**Martin Place Station Precinct - North Site (SSD 9270)
Design Changes**

The Department has reviewed the list of proposed design changes in the document prepared by Ethos Urban, titled *Conditions of development consent for the Sydney Metro Martin Place Station Precinct SSD 9270 – North Site Condition B5, B6 and B7 discharge request #2 – Design excellence and design integrity review*, dated 15 September 2020.

Table A: Prior to issue of the relevant Construction Certificate

Table B: Prior to a future Section 4.55 Modification Application

**SYDNEY METRO - MARTIN PLACE
ROOF PLAN
GENERAL ARRANGEMENT**

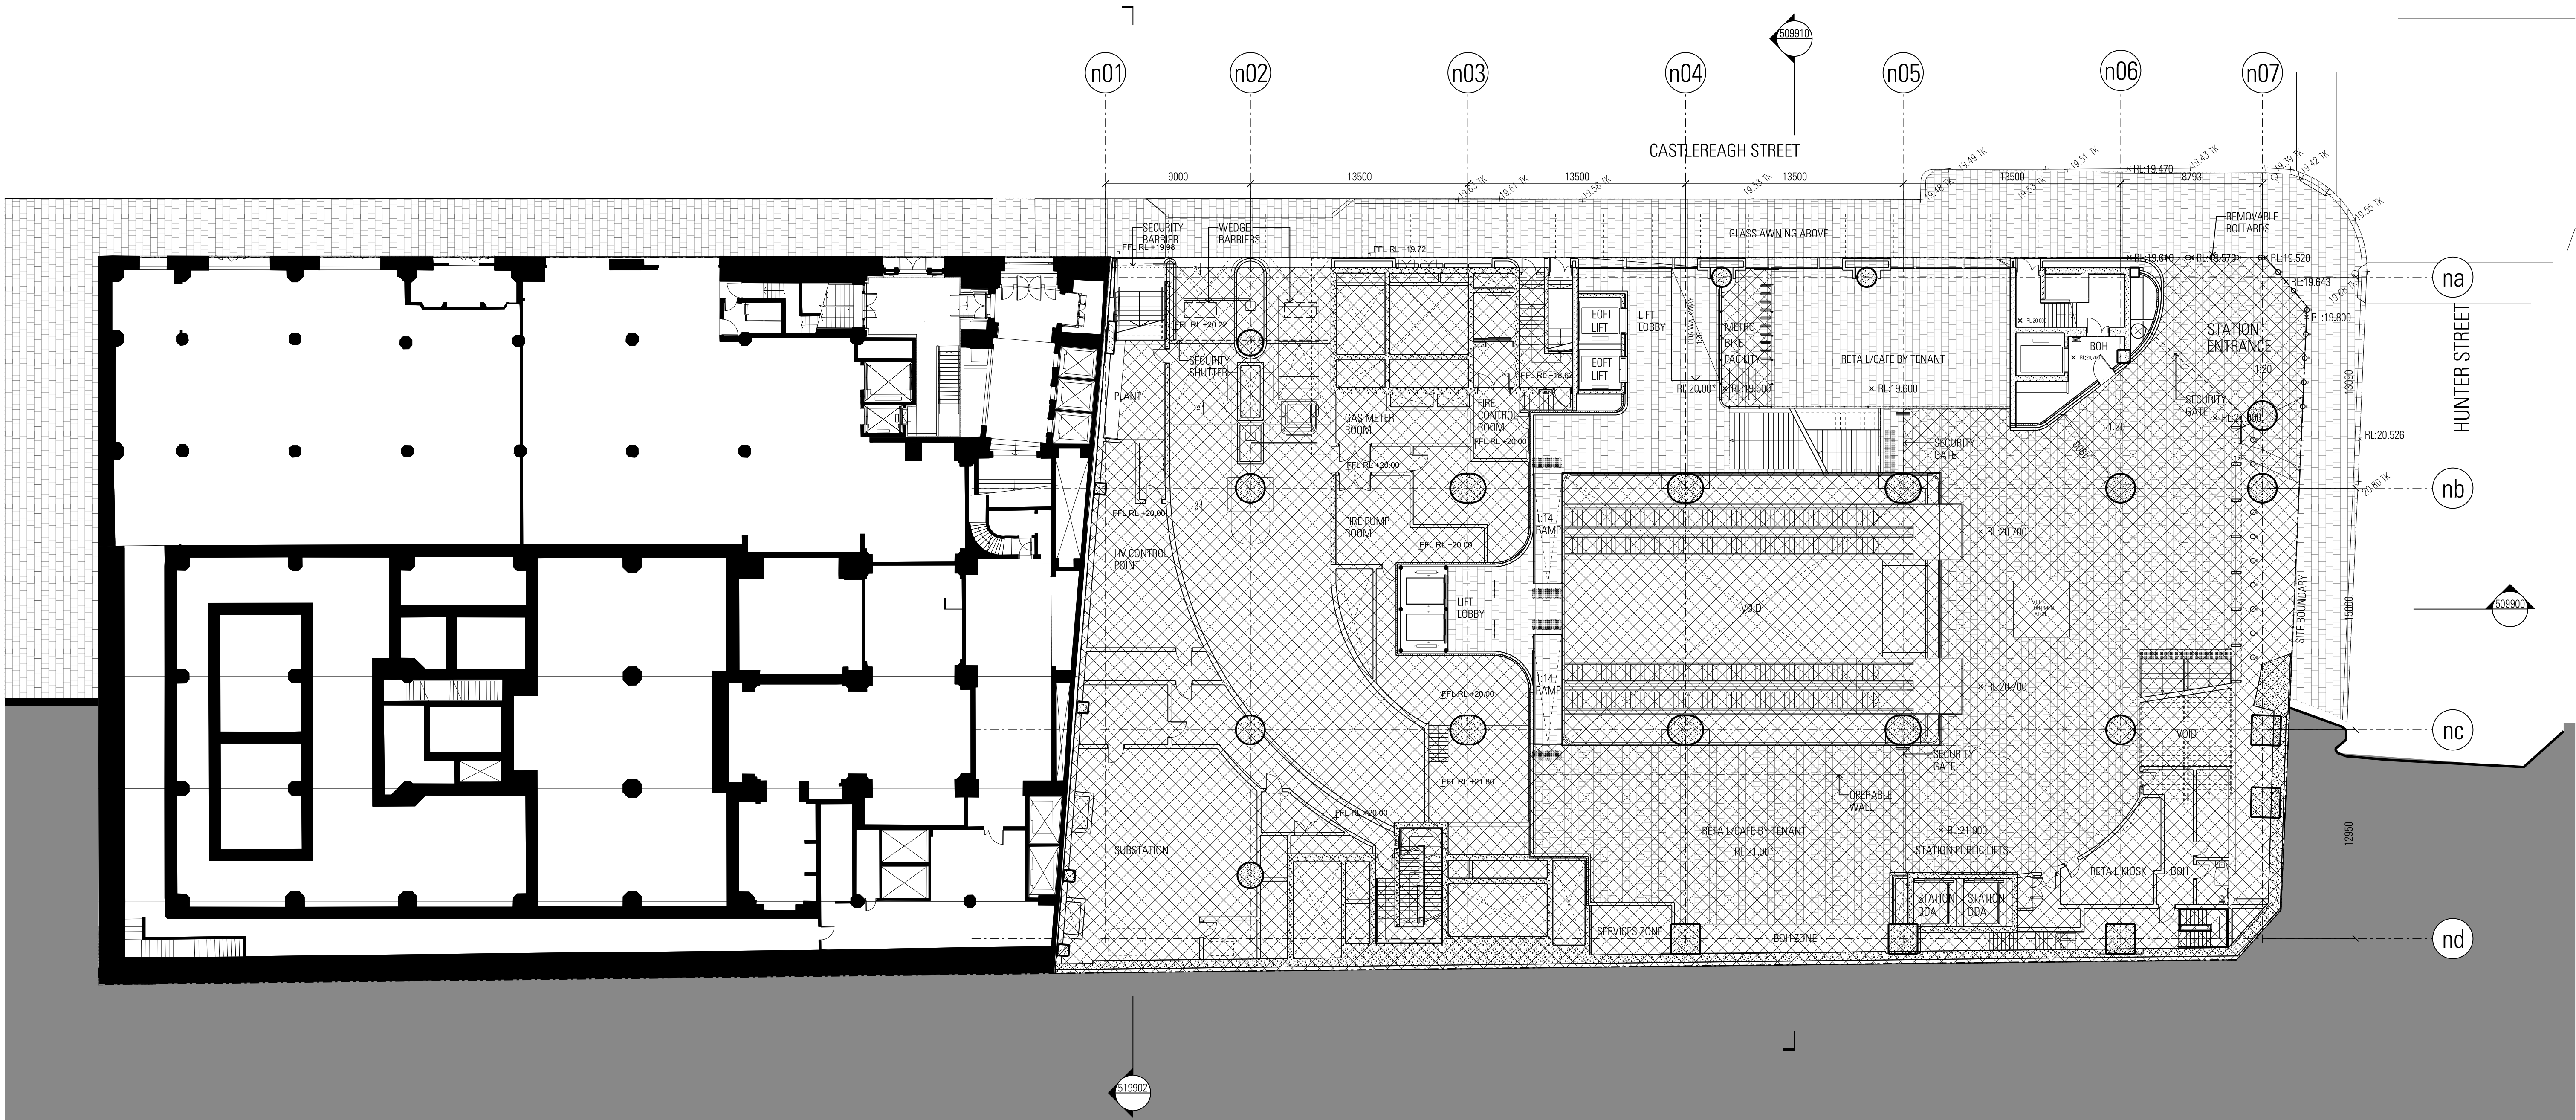
Design Change
Services coordination: Air plenum detail added to the internal fire pump room on the roof plan.
